Planning Application AW/159/13 (78 Barrack Lane)

We object to the above application to construct a 'New Detached Garage' in front of 78 Barrack Lane. It conflicts with Arun District Local Plan 2003 POLICY DEV 19:

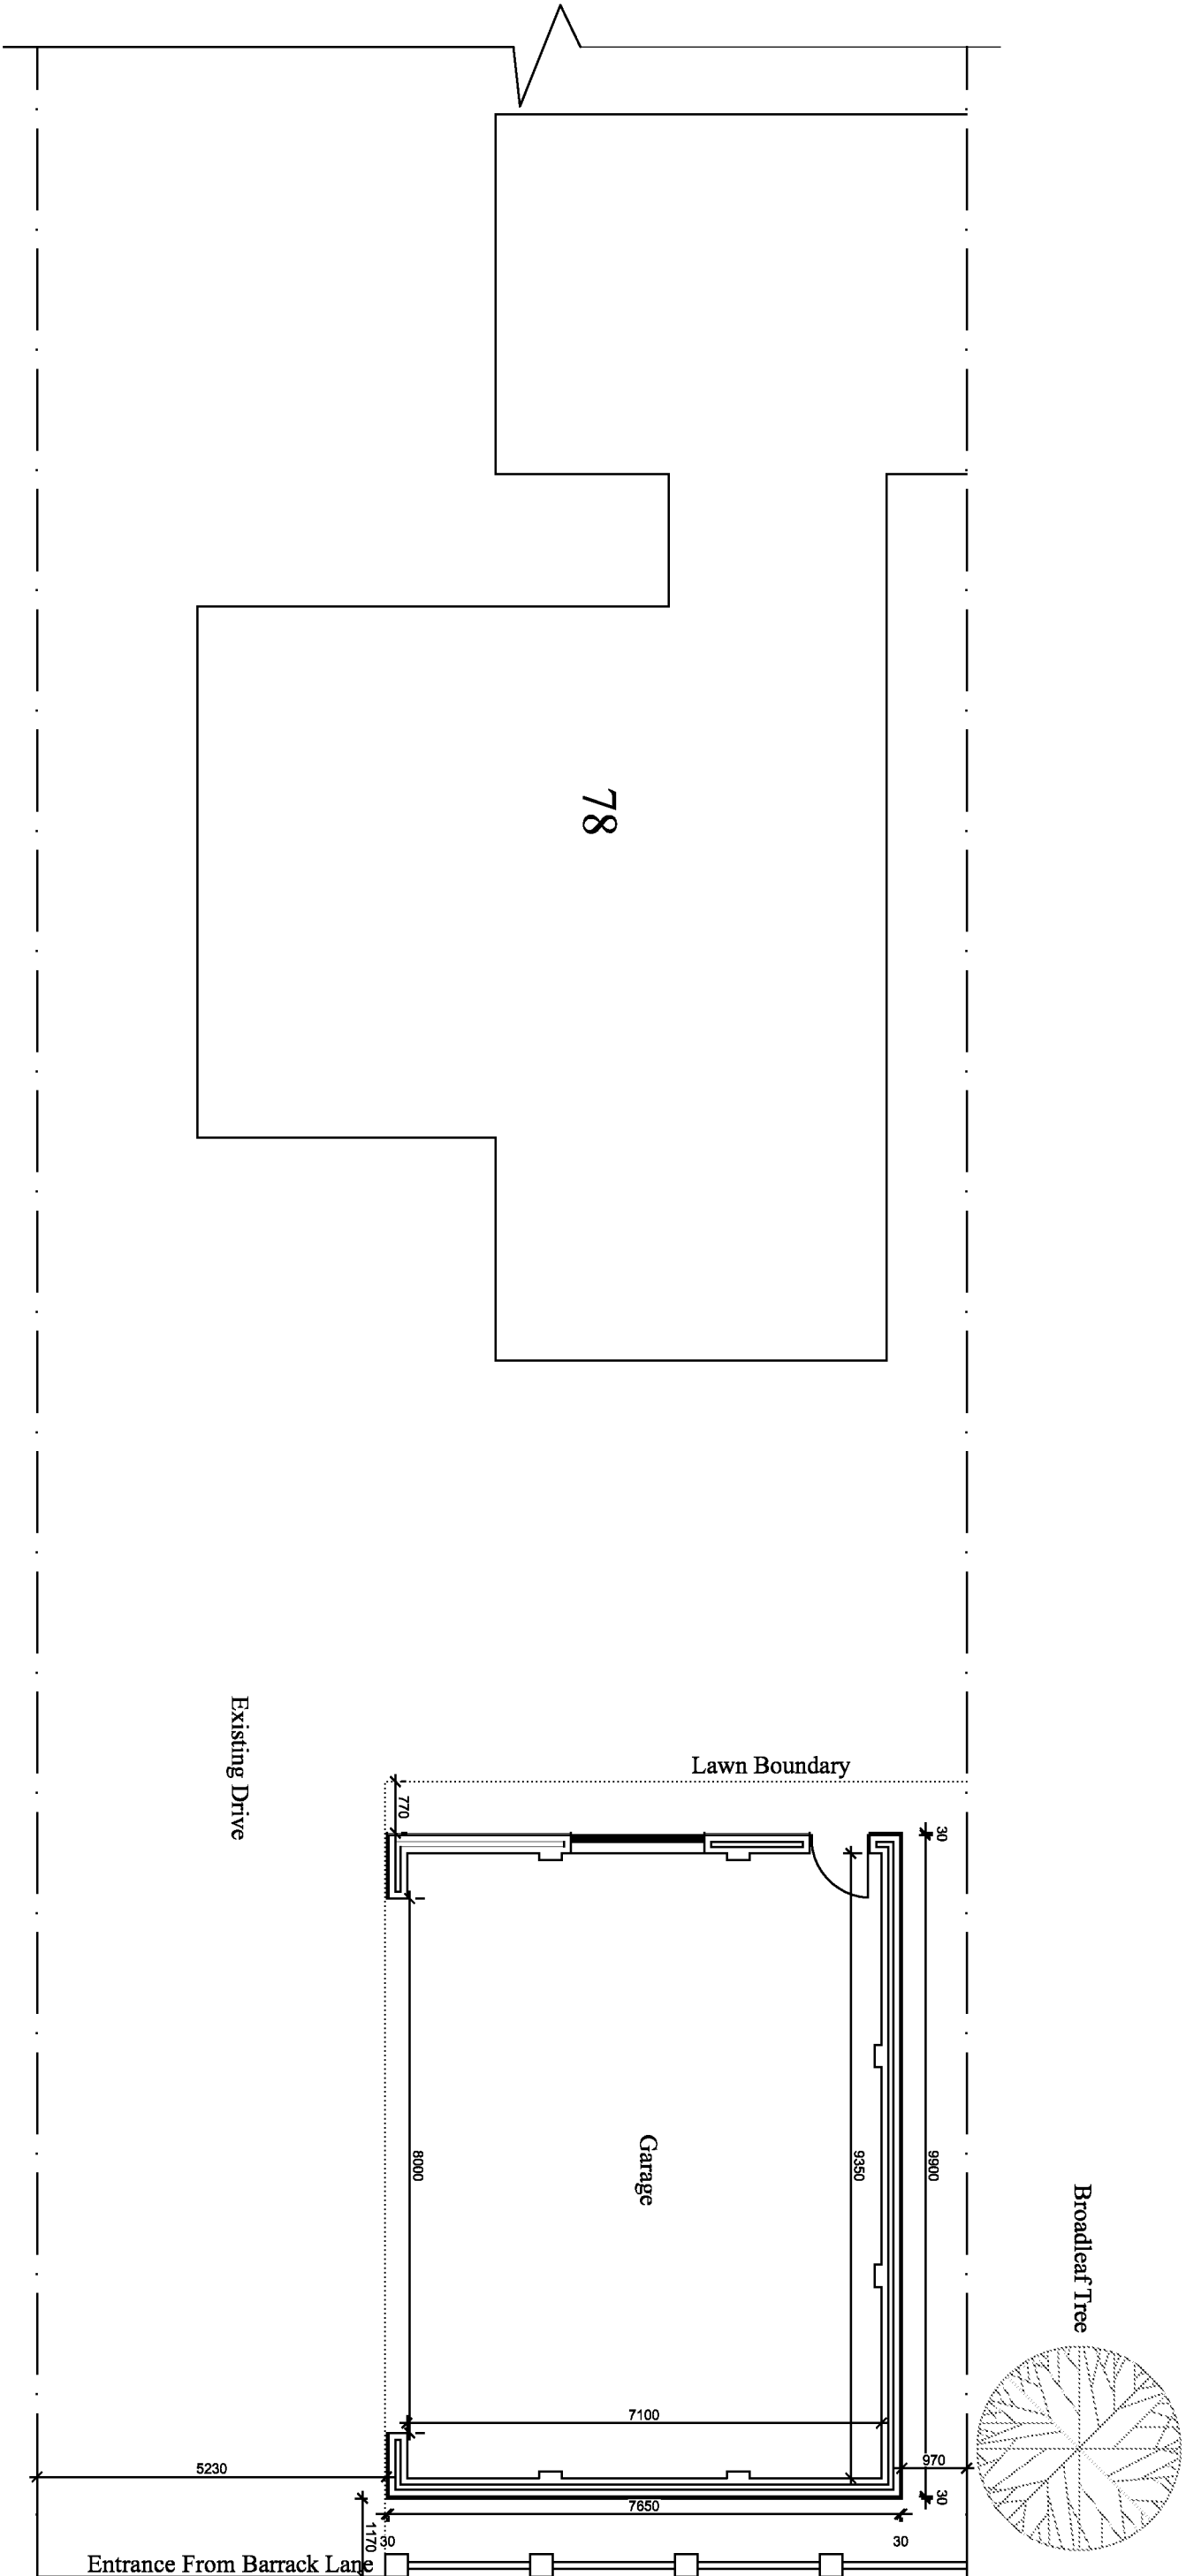
- (iv) The proposed garage is 'shoe-horned' into the existing space (barely a metre separating it from the front wall and the northern boundary) at the expense of the present open space occupied by a lawn which is currently compatible with the use of the front of neighbouring properties. If approved the garage would be incompatible and out of keeping with the ambience of the neighbourhood and *rather than contribute to would detract from* the immediate environment.

- (vi) The broadleaf tree in the south-east corner of 76 Barrack Lane abutting the proposed site of the garage is subject to a Tree Preservation Order and digging foundations for a new garage would irreparably damage the roots

There are additional concerns such as the angle of vehicular access from Barrack Lane into the proposed garage which would require skilful manoeuvring from the highway into a narrow drive. Any obstruction and delay to entry could cause a hazard and danger to vehicles travelling along Barrack Lane.

Proposed Front Elevation - Street View

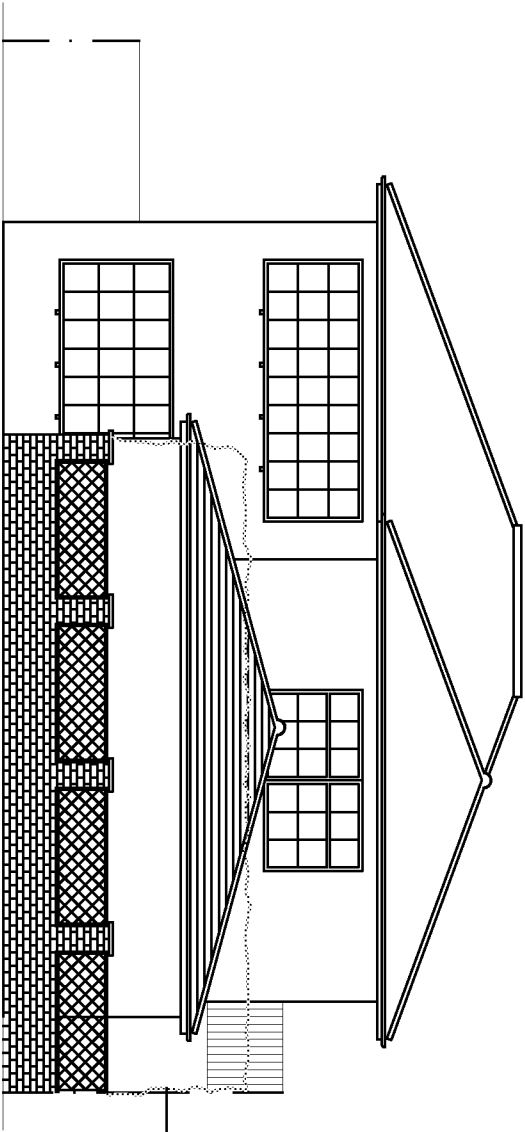
Finally, a correction on a matter of fact. The plan of the Front Elevation (03) is annotated '*hedge to be planted which will grow to screen garage similar to property opposite*'. The fact that the applicant considers it necessary to plant a hedge to screen the garage is an admission that he is conscious of its impact. 'Opposite' is 71 Barrack Lane. The beech hedge on this property was not planted to screen the garage but to mark the front boundary of the property at the time it was planted. The beech hedge stands 20 metres from the garage (not barely a metre as in the proposed hedge in 78 Barrack Lane) which is integral to the house and built simultaneously well within the building line existing in 1981. To attempt to draw a comparison between the proposed screening hedge and the established beech hedge is absurd.

There are other considerations surrounding the proposed screening hedge such as the species, the length of time it will take to grow, the narrow space between the garage wall and the front wall which is inimical to pruning, maintenance etc as access along the whole length would be impossible. We know from experience that in this environment self-seeding weeds, brambles and ivy require constant attention and access along its entire length. Given the narrow space the proposal to plant (and maintain) a hedge is unrealistic.
